From: Jo Funnell (Funnell Design) [REDACTED]
Sent: 21 July 2021 11:30
To: Jasmine Kaur Singh <Jasmine.KaurSingh@arun.gov.uk>
Subject: RE: LU/145/21/PL - 12 Cornwall Road Littlehampton BN17 6EE

Subject: RE: LU/145/21/PL - 12 Cornwall Road Littlehampton BN17 6EE

I have taken a look at the revised plans and unfortunately it raises some other concerns.

Drawing Title
Proposed Ground and First Floor Plans

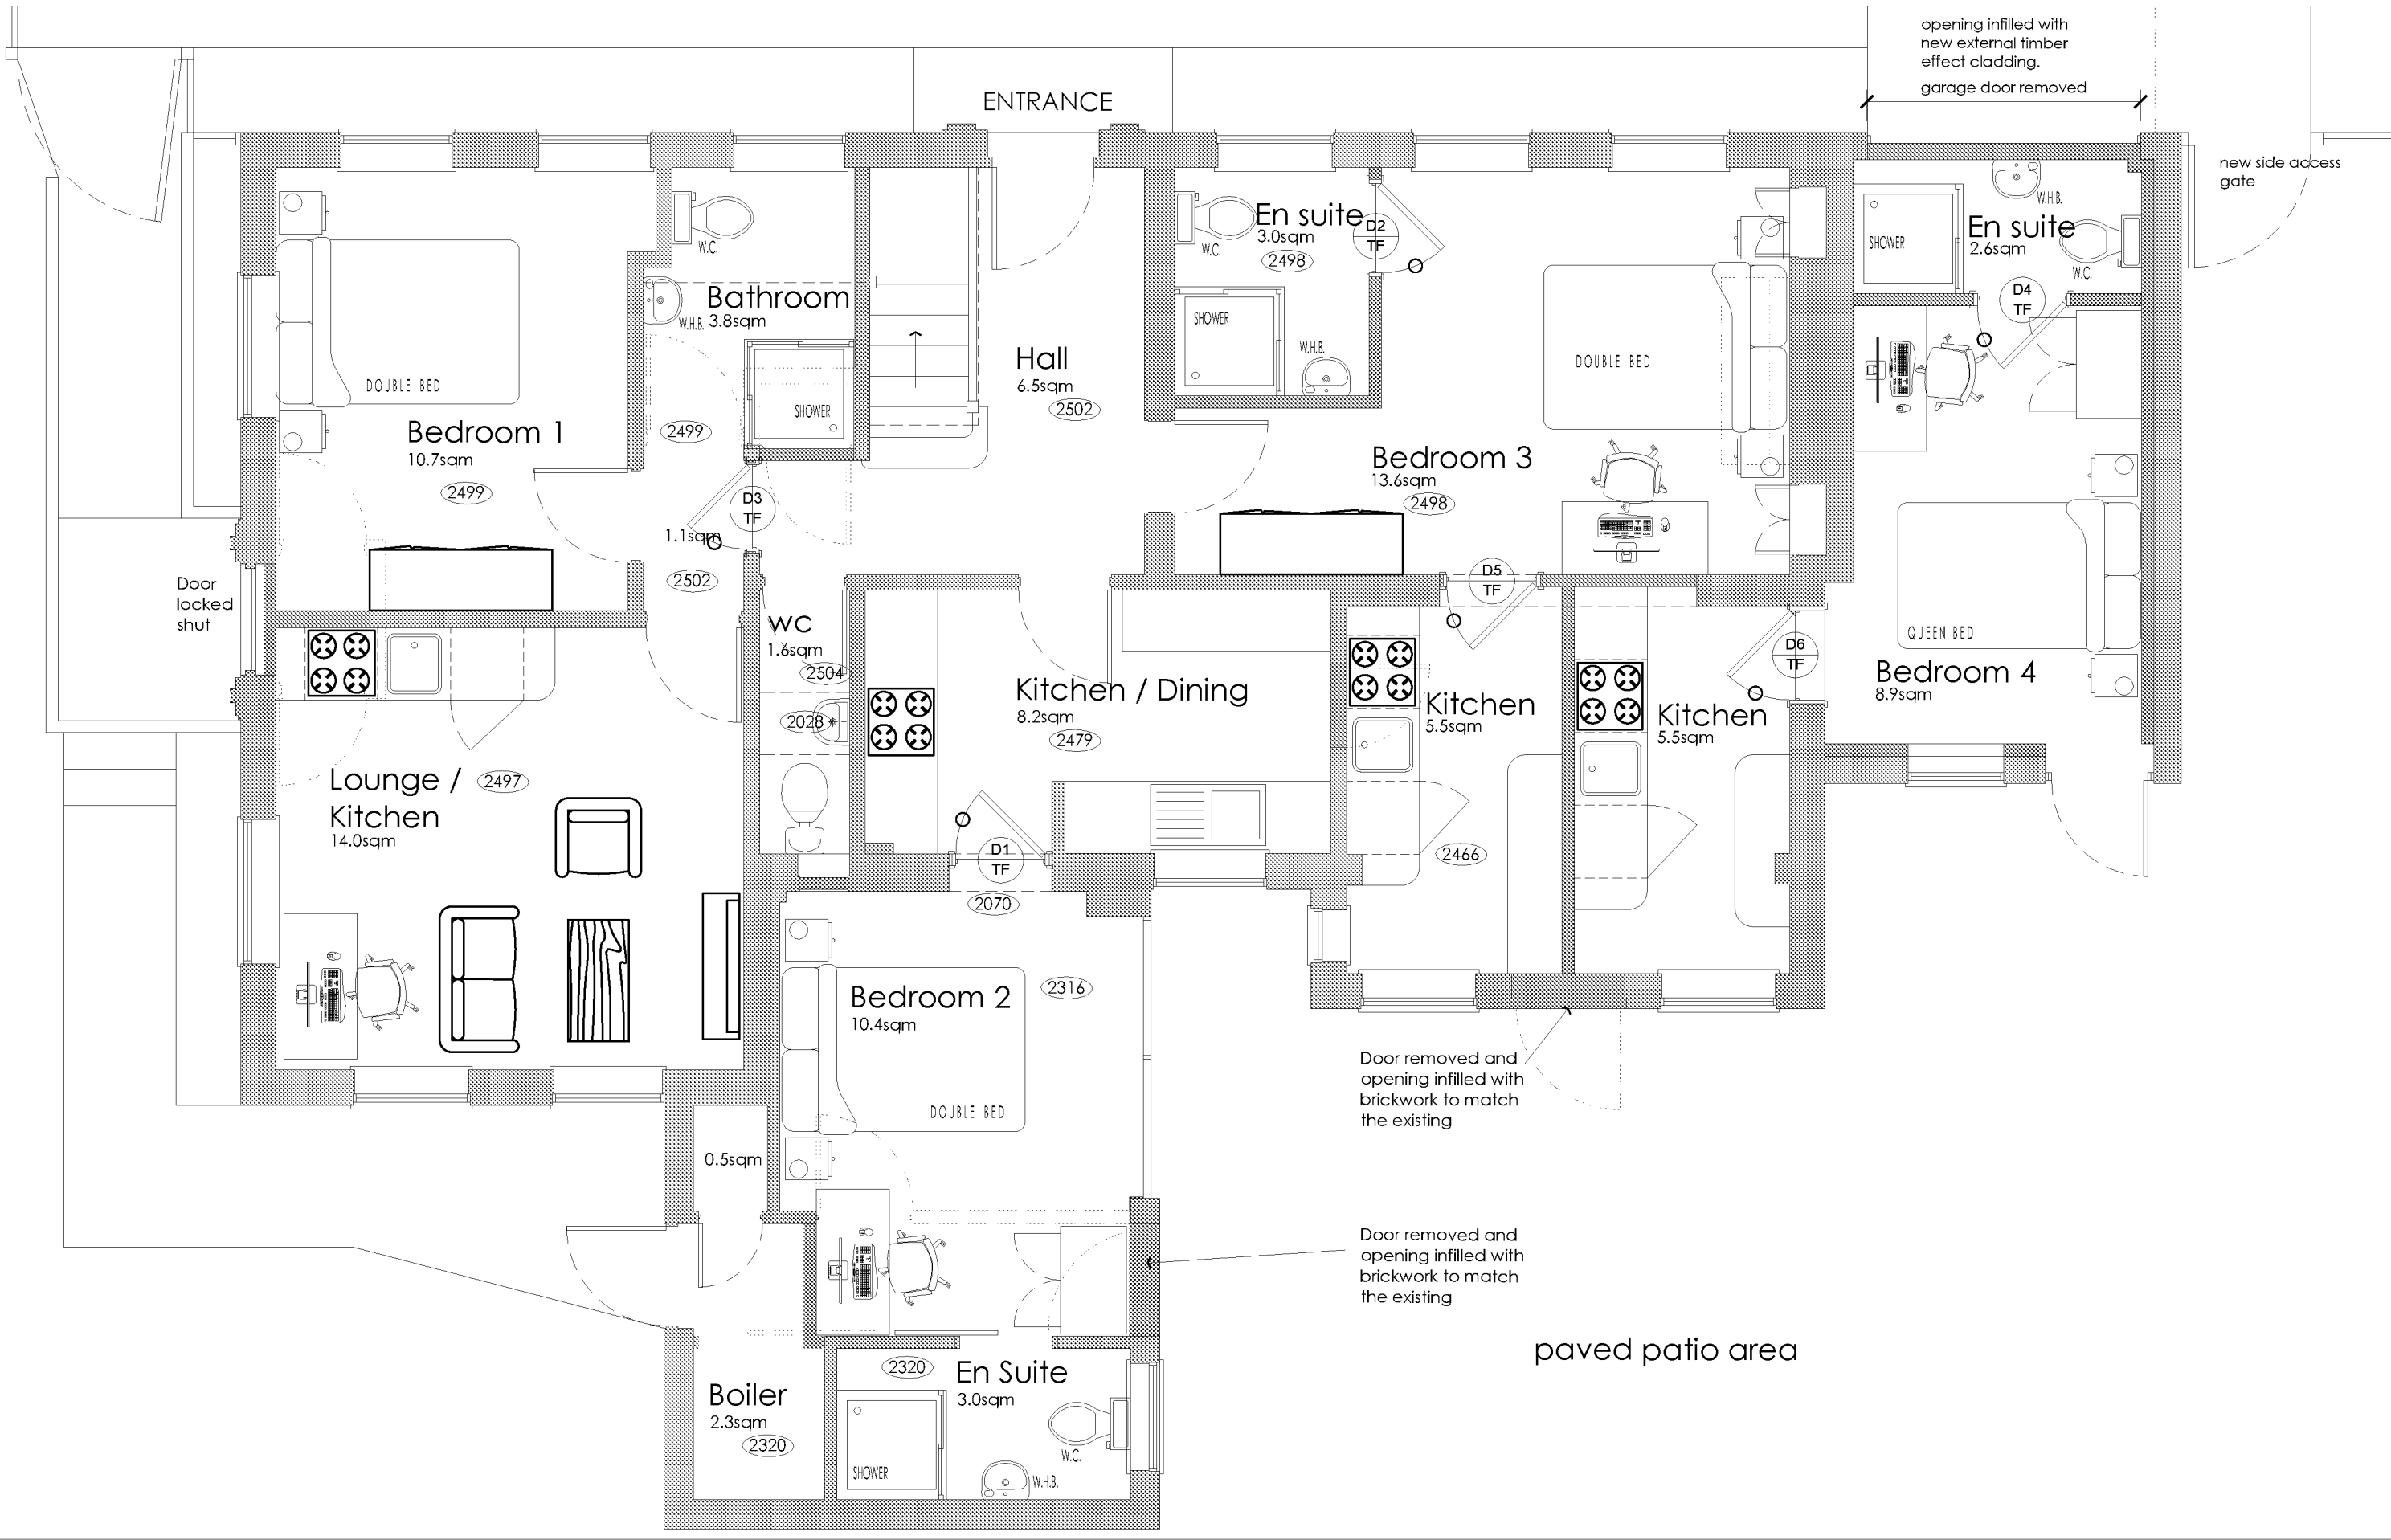
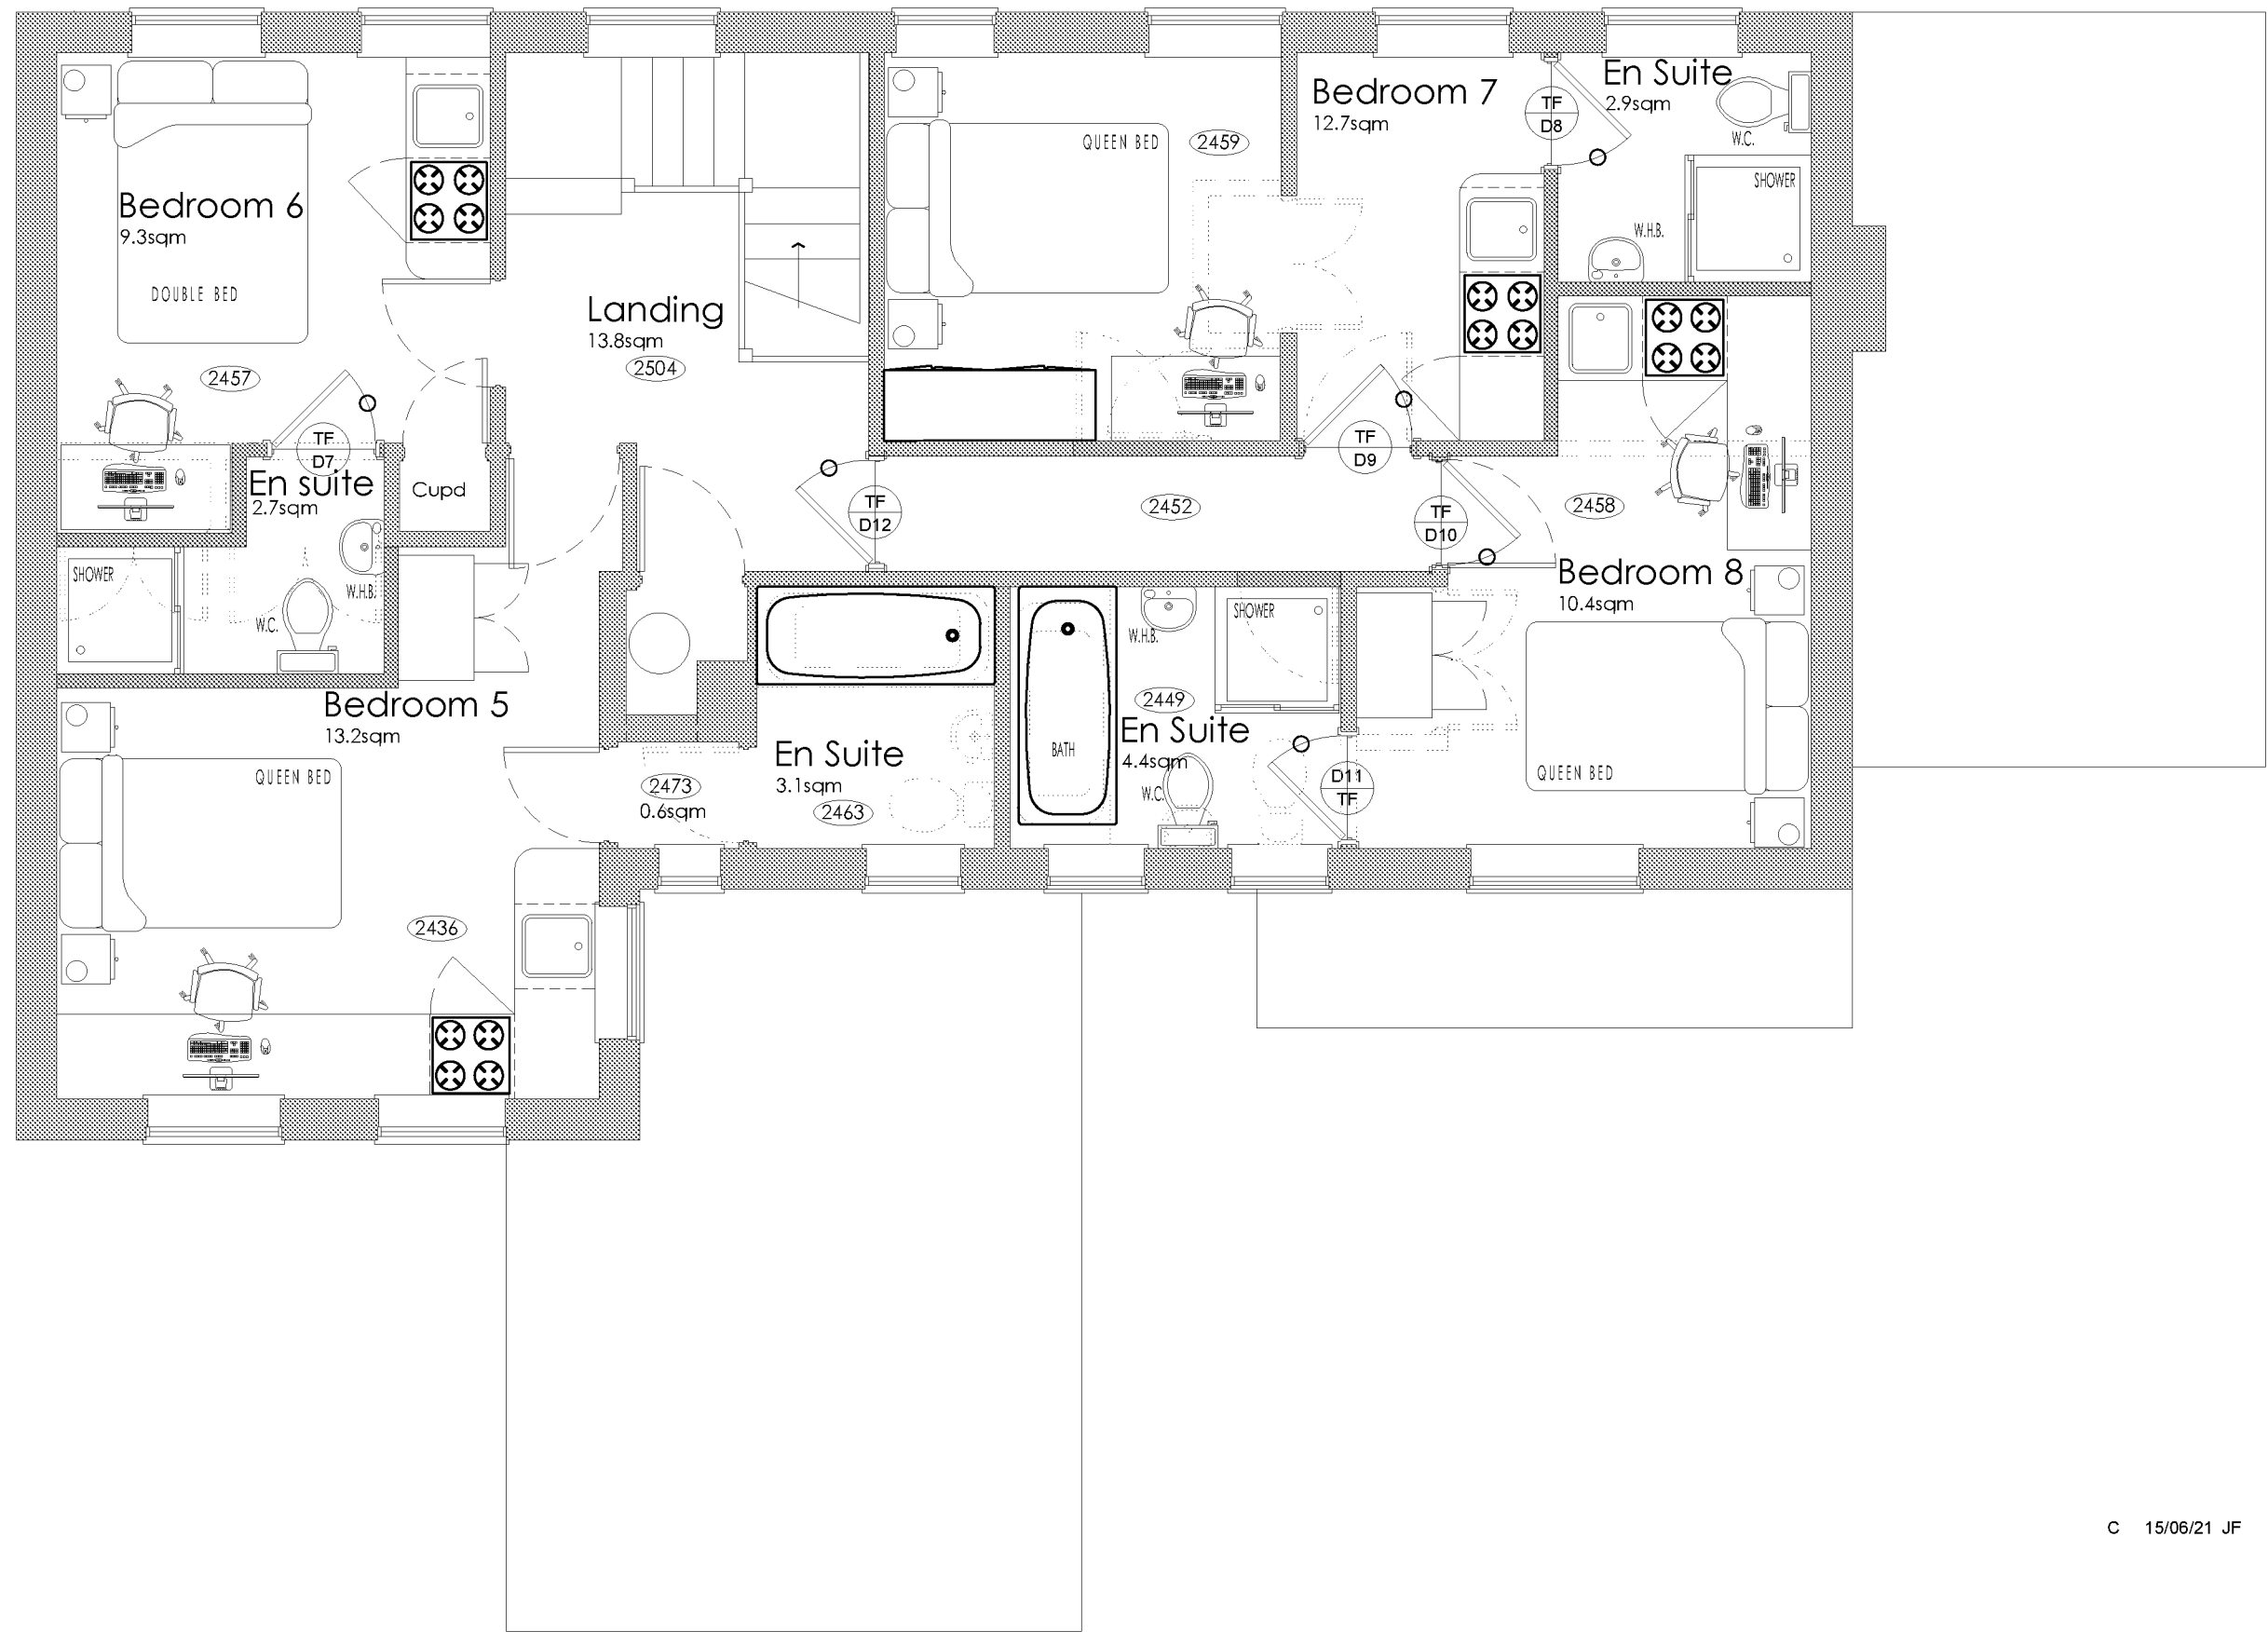
- Room 2 comprises an inner room as egress from the bedroom/living area is via the kitchen. A room where the only escape route is through another room is termed an “inner room” and poses a risk to its occupiers if a fire starts unnoticed in the outer room. Either an escape window or a door should be installed to the bedroom, but an escape window should only be considered if all of the following criteria can be met:

- They serve rooms whose floor level is no more than 4.5m from the ground;
 - Every room served by the escape window has access to it without entering another habitable room;

- If it is necessary to pass through the escape route to reach the window, consideration should be had to the travel distance involved;
 - Occupiers are able-bodied individuals who can reasonably be expected to exit via the window unaided;

- There is no basement well or other encumbrance beneath the window such as railings or a conservatory;
 - The escape window is openable from the inside without the need for a key and the ground below is level and free of obstructions; and

- The window should lead to a place of ultimate safety. However, if this leads into a courtyard or back garden where there is no exit, it should be at least as deep as the building is high

- Room 7 poses a similar risk where egress from the unit is located closer to the kitchen area rather than the living area, resulting in the occupant having to directly pass the kitchen in order to exit the property. Consideration should be given to reconfiguring the layout of this room, or to install an escape window providing all of the above criteria can be met.

- As these rooms are now self-contained units, some of the rooms are potentially undersized. The minimum room sizes detailed within Arun’s HMO Standards are as follows;

Looking at the room sizes on the plan, the following rooms may be considered undersized:

Room 4: Living/bedroom – 8.9m² (min. 10m²)

Room 6: Studio area – 9.3m² (min. 13m²)

Room 7: Studio area – 12.7m² (min. 13m²) – admittedly this is only just undersized

Room 8: Studio area – 10.4m² (min. 13m²)

- It seems unlikely adequate kitchen provisions will be provided to a number of rooms, given the available space and proposed layout of the plans. A kitchen should provide the following:

Based on the plans, it seems likely that rooms 5, 6 and 8 would have difficulties achieving this.

- The internal escape route should provide 30 minutes fire resistance, including the provision of 30-minute fire resisting and self-closing fire doors (FD30S) to each unit and along the first floor landing, including the cupboard if there is a source of ignition
- A mixed Grade D1 fire system to be installed to the property.

Interlinked mains wired alarms with integral tamper-proof battery back-up to be located:

- throughout the escape route (smoke)
- within the first floor landing cupboard if a source of ignition is present (smoke)
- in each unit to the room/lobby opening onto the escape route (heat)

Non-interlinked mains wired alarms with integral tamper-proof battery back-up to be located:

- in each unit to the room/lobby opening onto the escape route (smoke)
